From: Laura Gibbons
Sent: 24 May 2019 12:49
To: Planning.Responses
Subject: BE/135/18/PL- Salt Box

Engineers Further Comments Regarding Surface Water Drainage

Owner:	LANDLINK ESTATES
Acres:	MOUNTFORD PIGOTT
Project:	SALTBOX SITE BOGNOR REGIS
Drawing Title:	PRELIMINARY DRAINAGE STRATEGY SHEET 2 OF 9

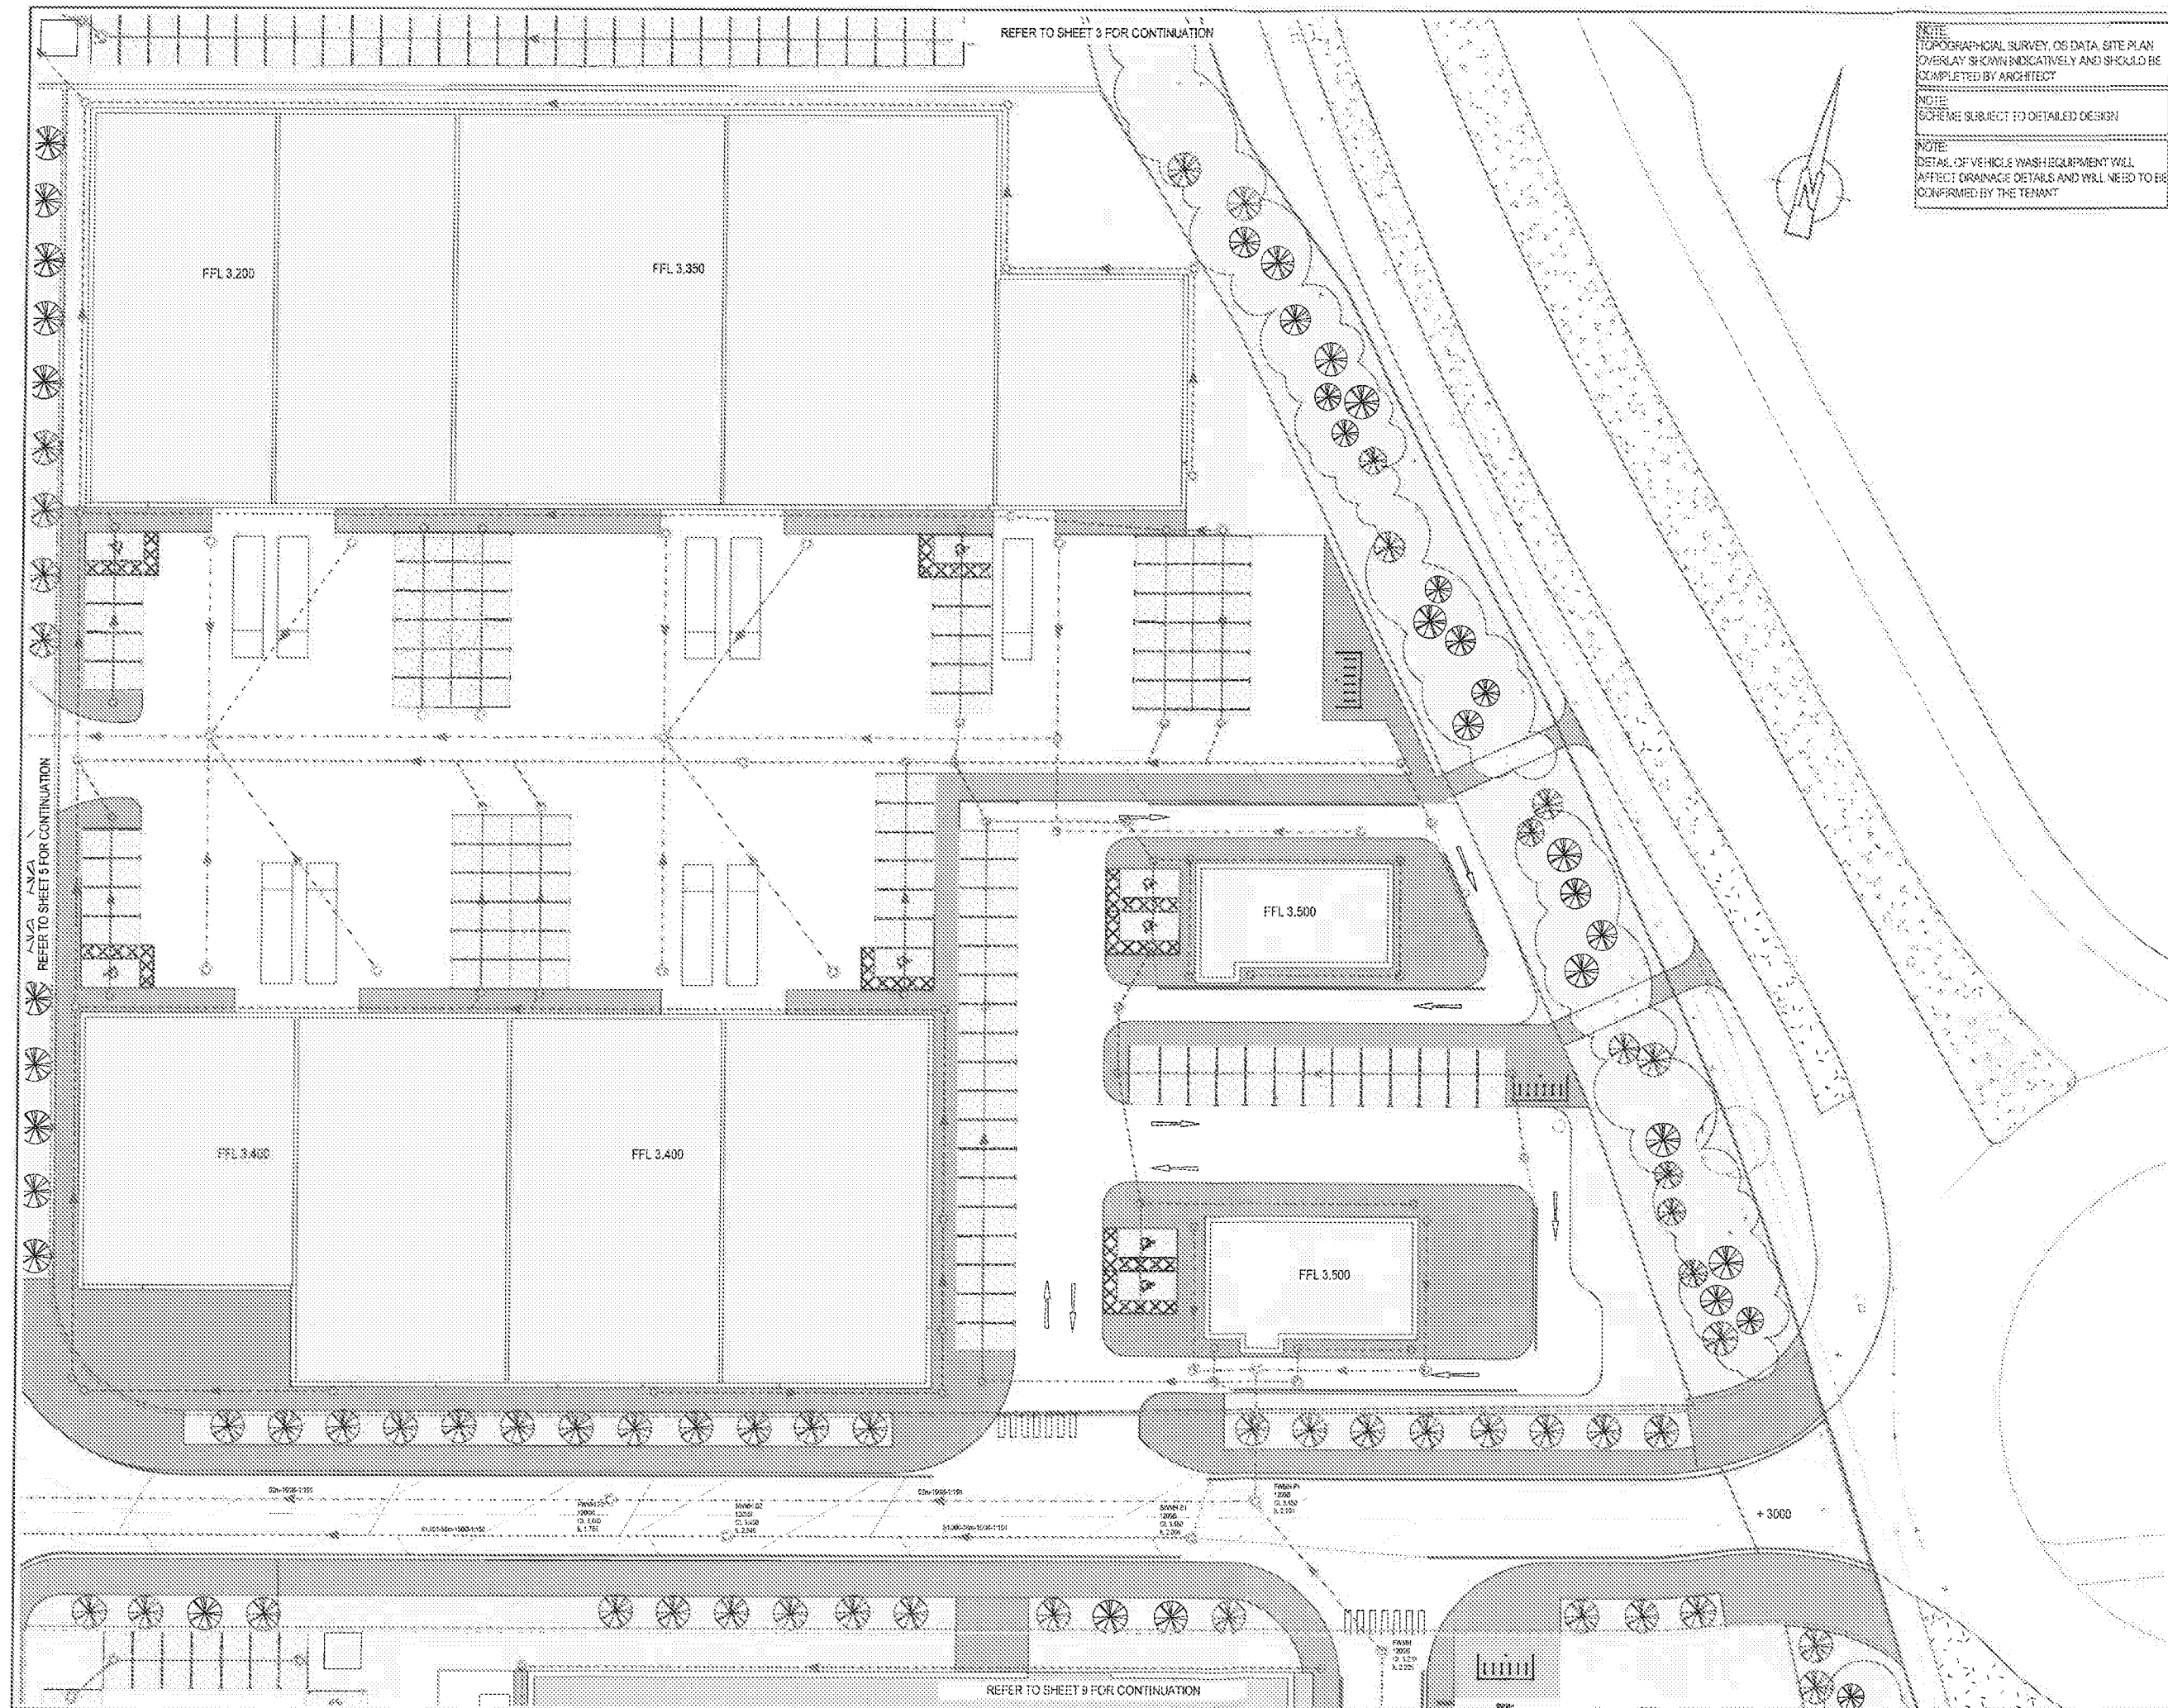
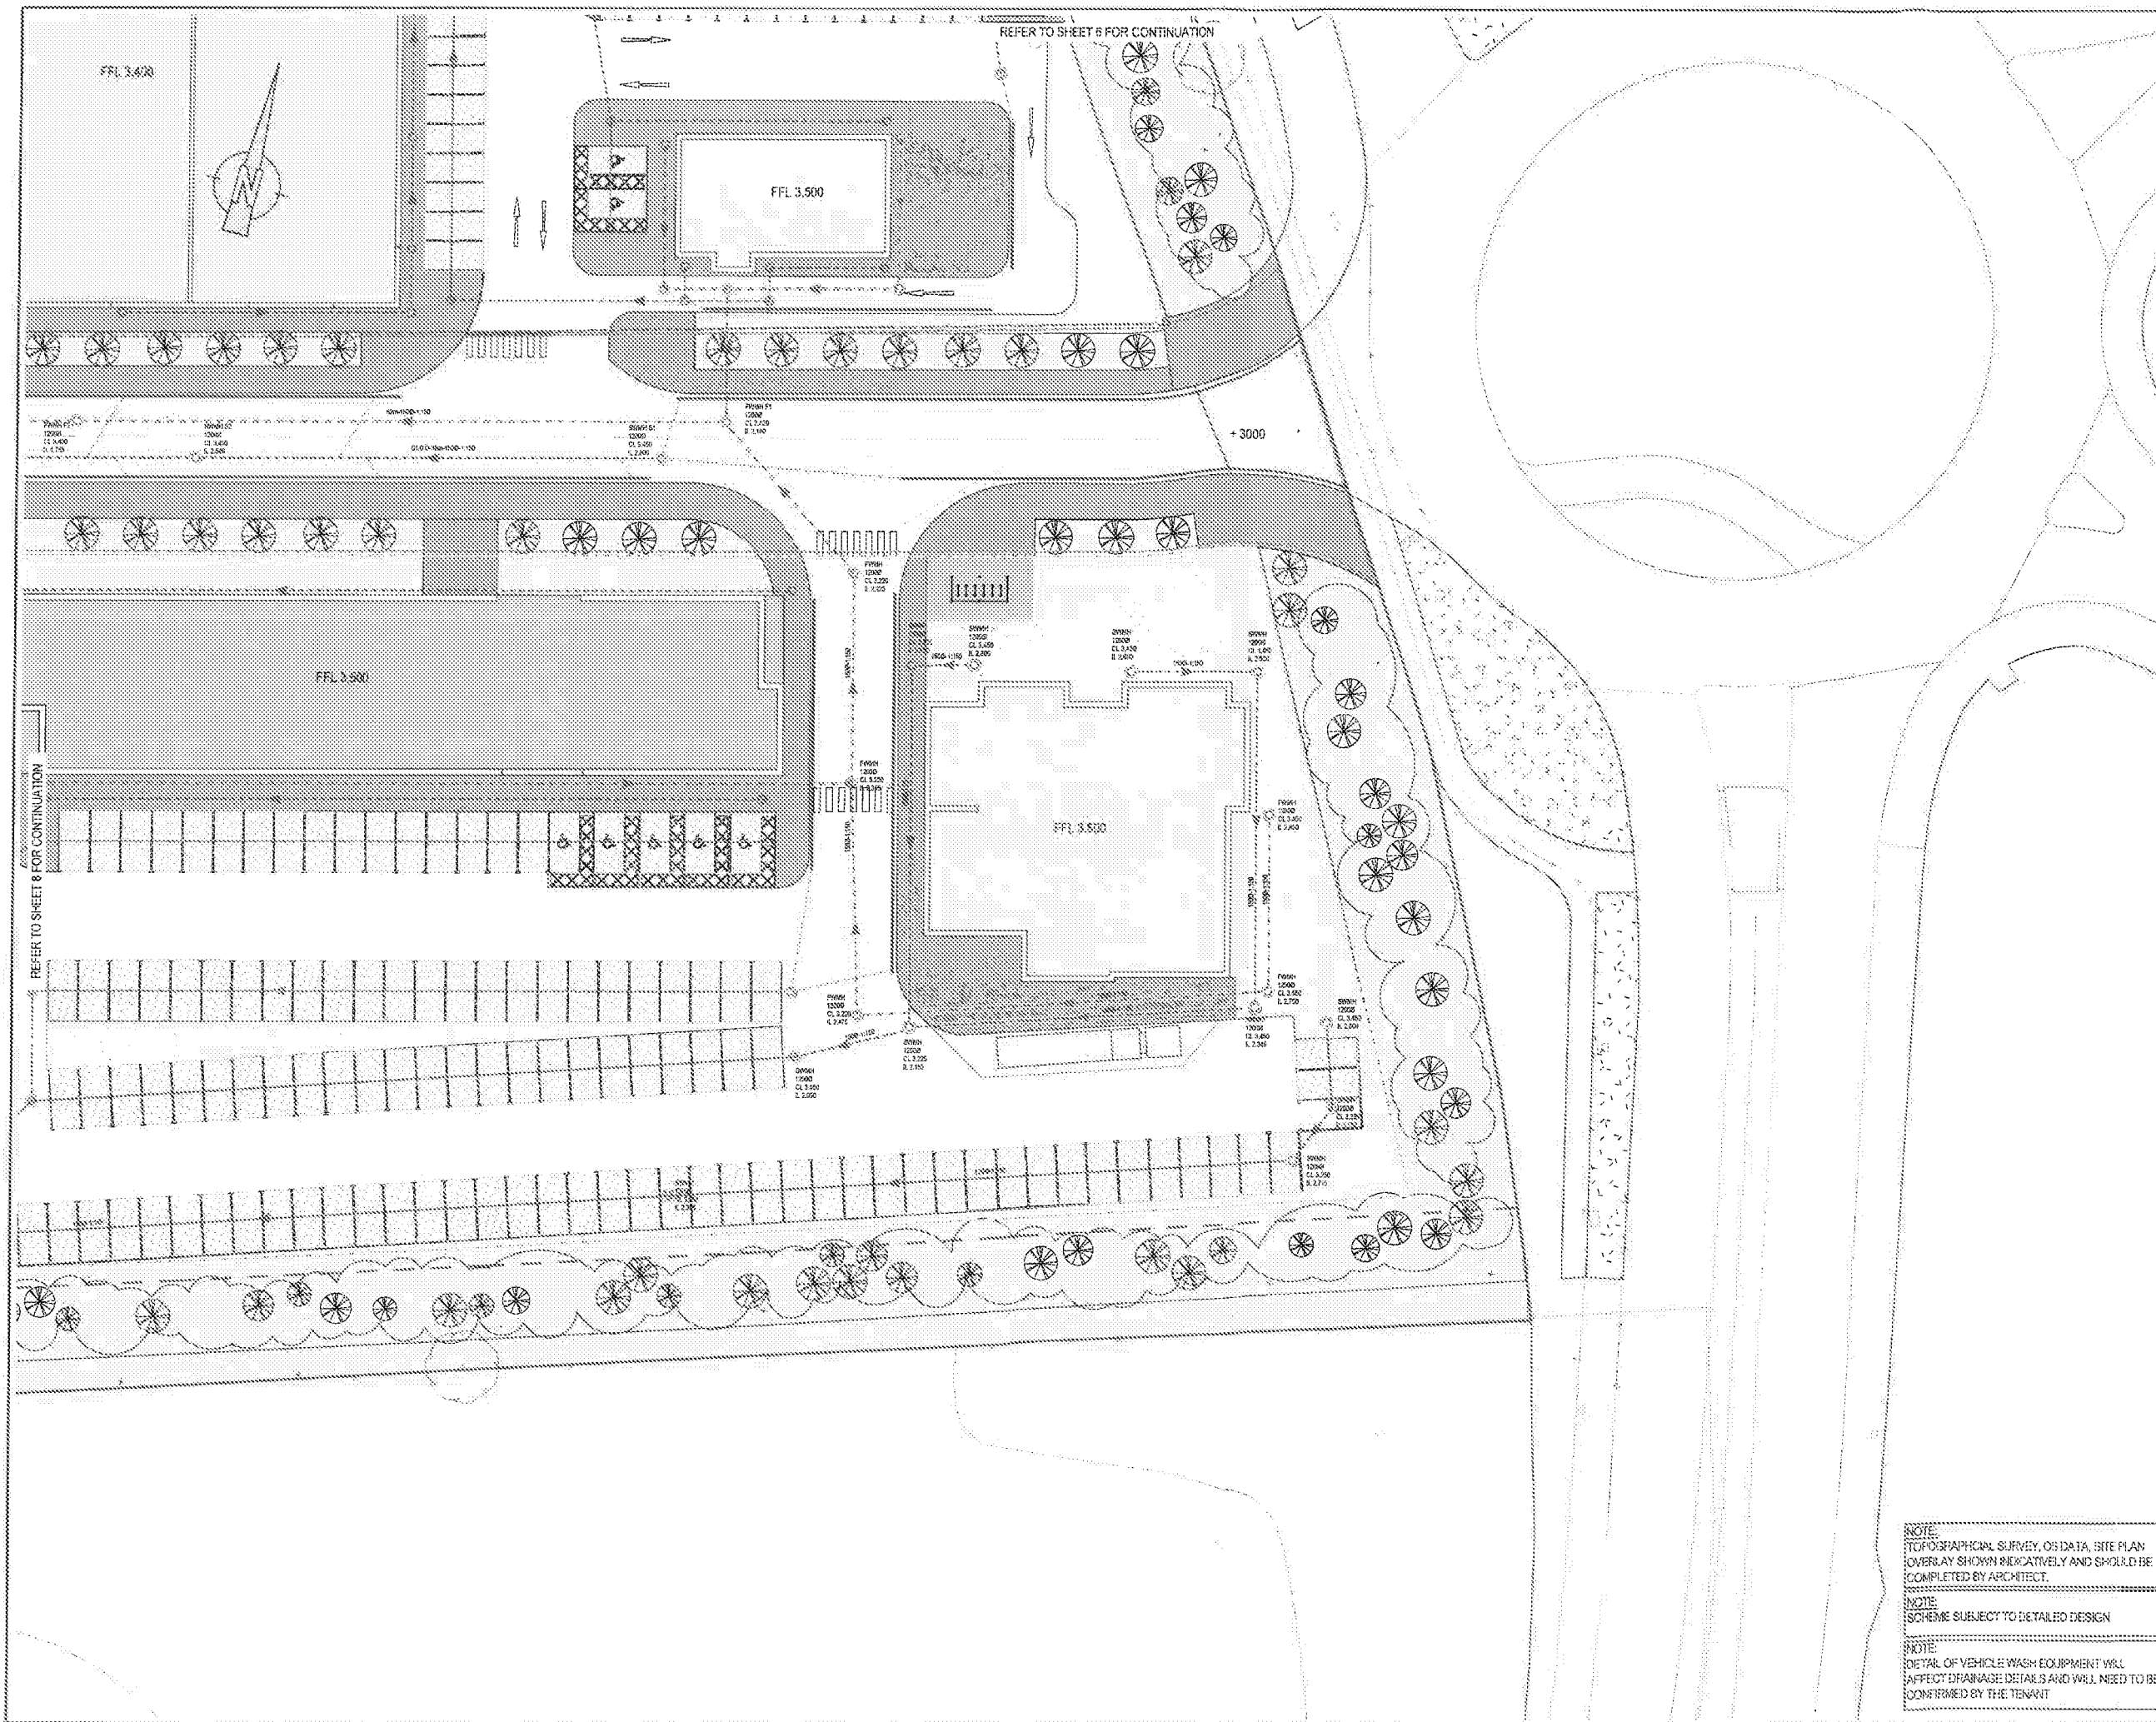
Insufficient information has been submitted to demonstrate that the site can be adequately drained. As a result, the proposals as they currently stand could increase flood risk elsewhere or to the development itself.

The four attenuation basins lie within the extents of the most up to date 1 in 100 year plus climate change modelled fluvial event (as provided by the Environment Agency) this means that it is likely the surface water attenuation basins will be inundated with fluvial water and there will be insufficient room for surface water storage. The extent of groundwater monitoring to date is also poor, if basins are left unlined there is a risk some of the free volume could be taken up by groundwater. Furthermore, initial results from simulations by the applicant of surcharging the outfalls to typical winter water levels within the ditch also have shown that there is insufficient capacity currently provided.

It is my opinion that approving this application without evidence that there is adequate space for surface water drainage could result in a scheme being approved that cannot be implemented.

"Development shall not commence, other than works of site survey and investigation, until full details of the proposed surface water drainage scheme have been submitted to and approved in writing by the Local Planning Authority. The design should follow the hierarchy of preference for different types of surface water drainage disposal systems as set out in Approved Document H of the Building Regulations, and the recommendations of the SuDS Manual produced by CIRIA. Winter groundwater monitoring to establish highest annual ground water levels and winter Percolation testing to BRE 365, or similar approved, will be required to support the design of any infiltration drainage. No building / No part of the extended building shall be occupied until the complete surface water drainage system serving the property has been implemented in accordance with the agreed details and the details so agreed shall be maintained in good working order in perpetuity."
